KITTITAS COUNTY COMMUNITY DEVELOPMENT SERVICES

RE: Williams Boundary Line Adjustment (BL-23-00006) – Request for Information

Kittitas County Community Development Services has reviewed your boundary line application and would like additional information in regard to the following:

Existing Total

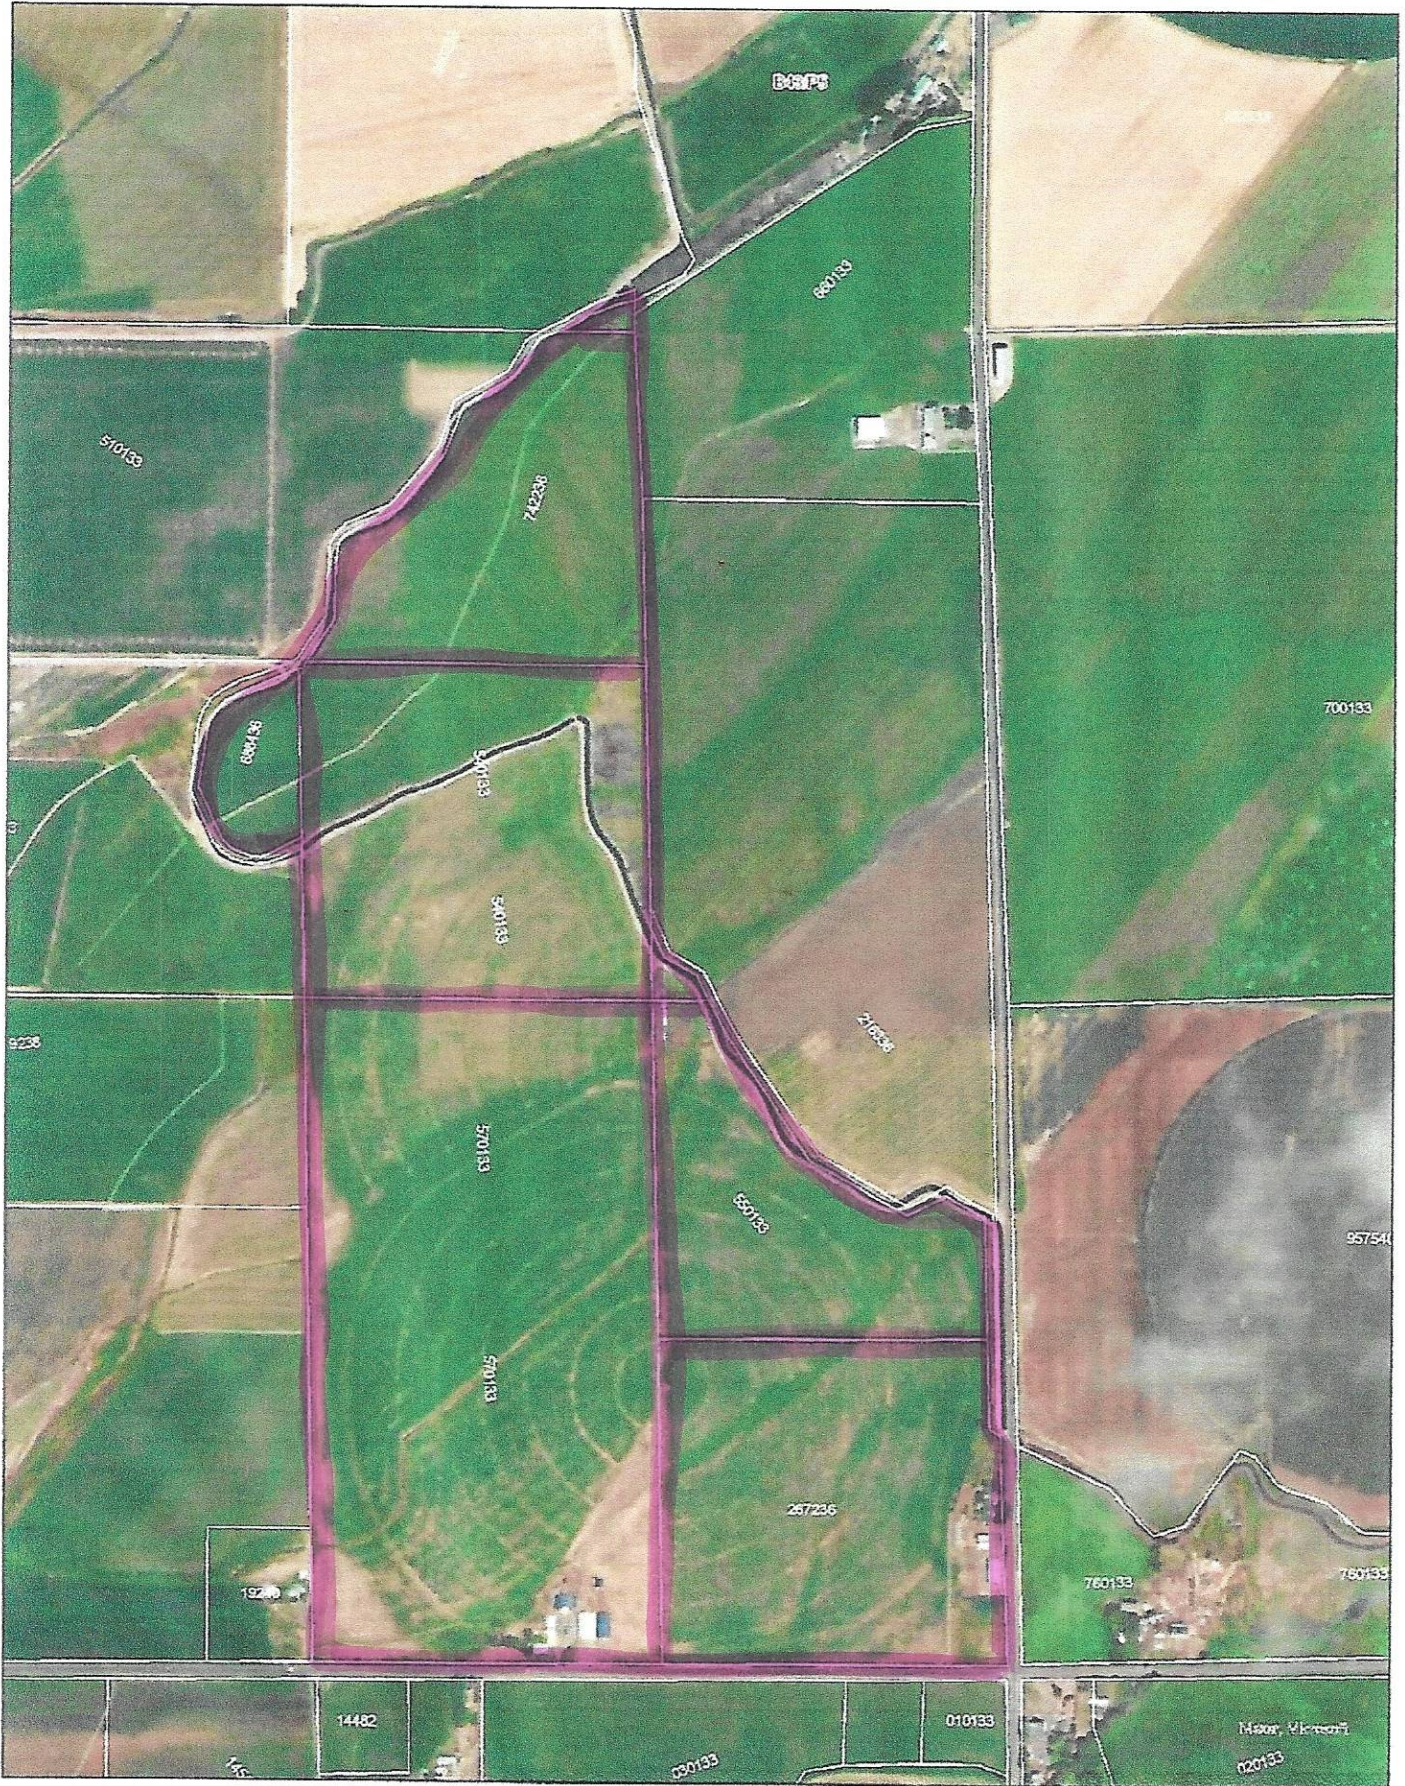
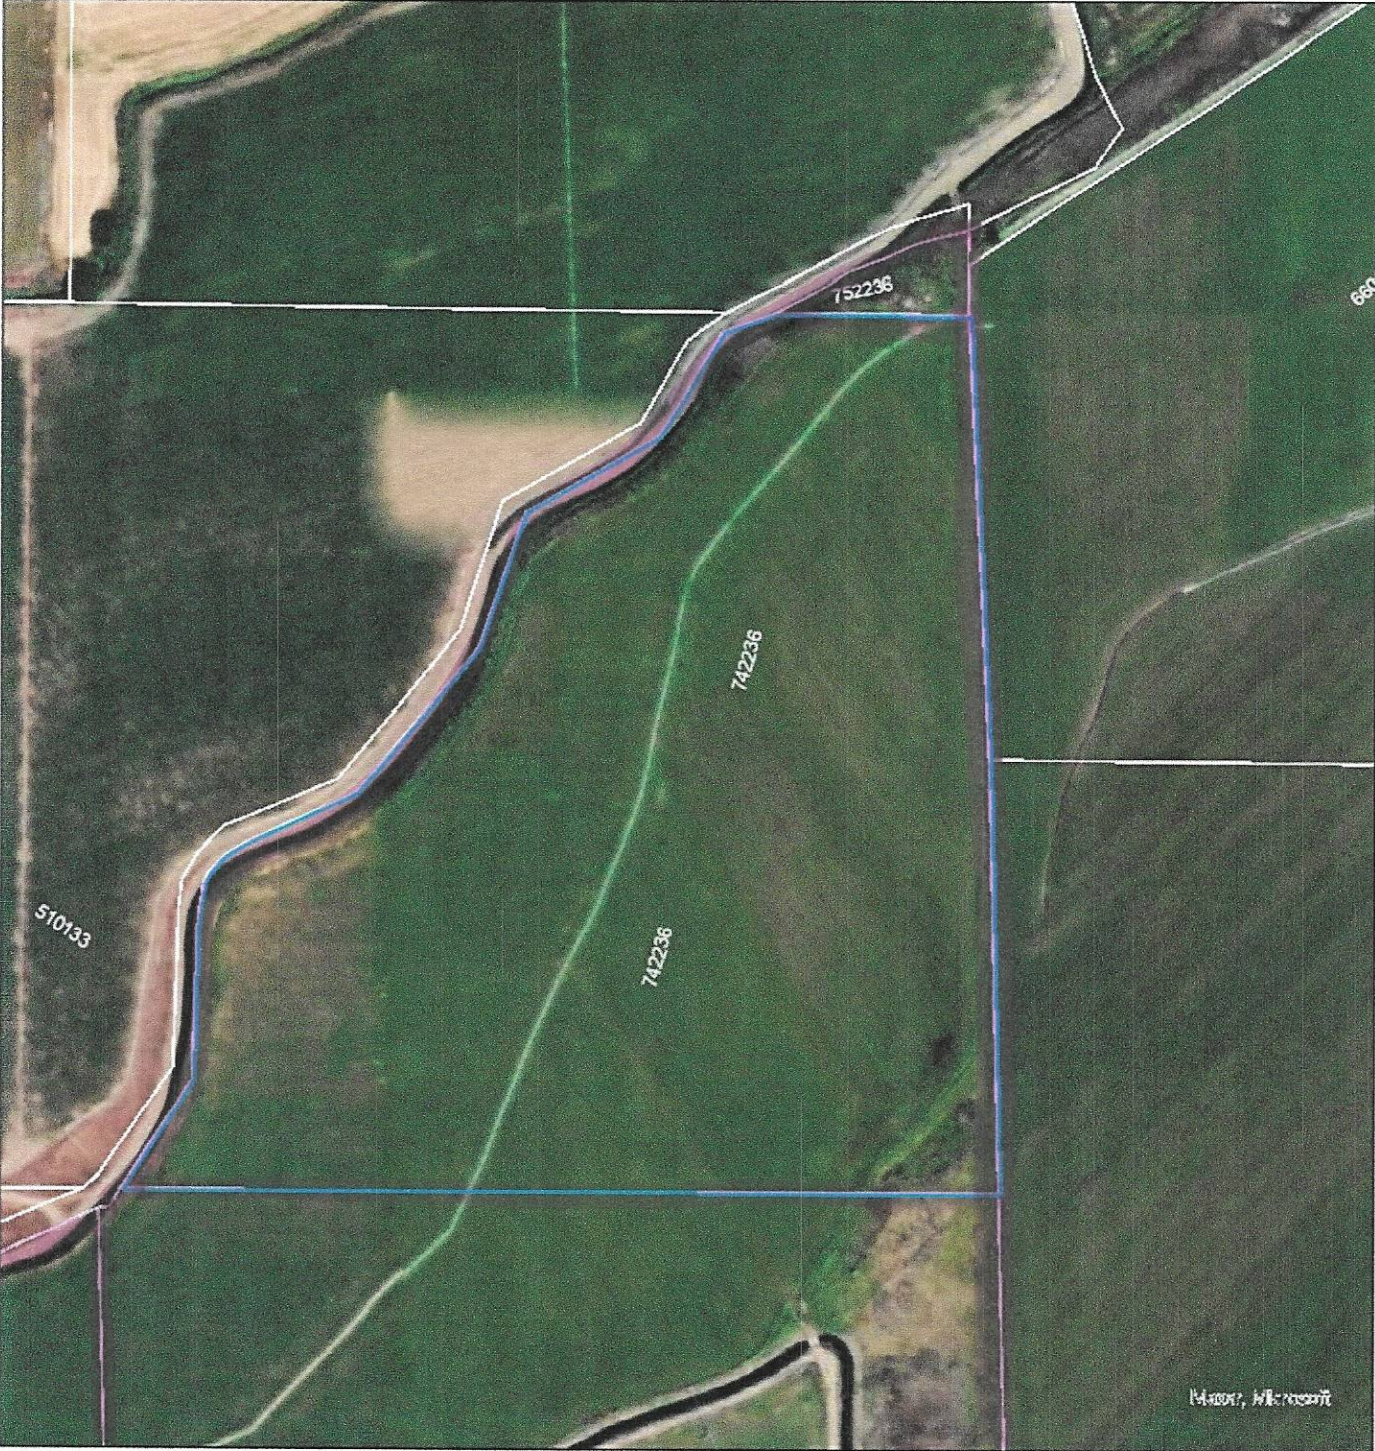
1. Existing and proposed acreages provided on your application do not match up correctly (the latter is less than what was started with by approximately 7 acres). Is this due to properties not being surveyed prior or something else? Please submit the existing and proposed boundary lines for this application with acreages for staff to review, or an explanation as to why the discrepancy in acreages exist.
